## **Reinforcement to the North Shropshire Electricity Distribution Network**

SP Manweb's Responses to Relevant Representations

Application Reference: EN020021

**Deadline 1 Submission**

### **Montgomery Canal Crossing**

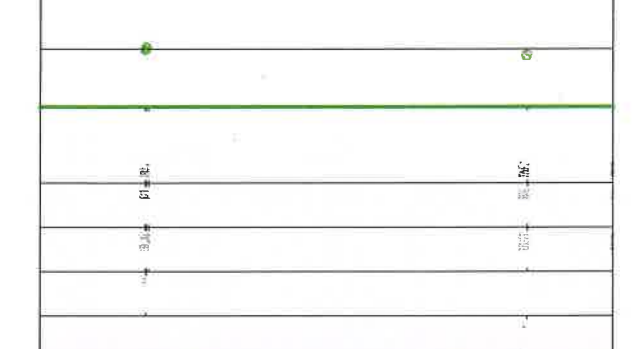
<b>Subject Matter</b>
As identified within the submission a section of the Montgomery Canal is a designated Site of Special Scientific Interest (SSSI) Although the canal is designated primarily for aquatic wildlife, it is also important as a flight line for birds and bats.
Therefore, it must be ensured that any overhead cable crossings have measures in place that reduce the chance of cable strikes by birds. Additionally, any construction phase activities should be kept away from the canal corridor to minimise any disturbance to the corridor.
The height of the overhead lines over the canal must be sufficient to ensure that access along the towpath to carry out essential maintenance and repair

of the canal infrastructure is not restricted. The height of any overhead lines must also be sufficient to ensure that boaters, towpath users, anglers and wildlife are not adversely affected. The power-line will require a localised “no fishing” safety restriction and anglers will need to be advised of the power lines via measures such as totem posts with no fishing signs on them installed on the towpath.

- 11.7. The design proposed by SP Manweb is in accordance with all the required design specifications. The height above ground of both poles either side of the Canal (nos. 37 and 38) is 13m. The height of the conductors are 9.3m on the western side of the canal and 9.9m on the eastern side. These heights allow for sufficient clearance to not adversely affect users of the canal or towpath.
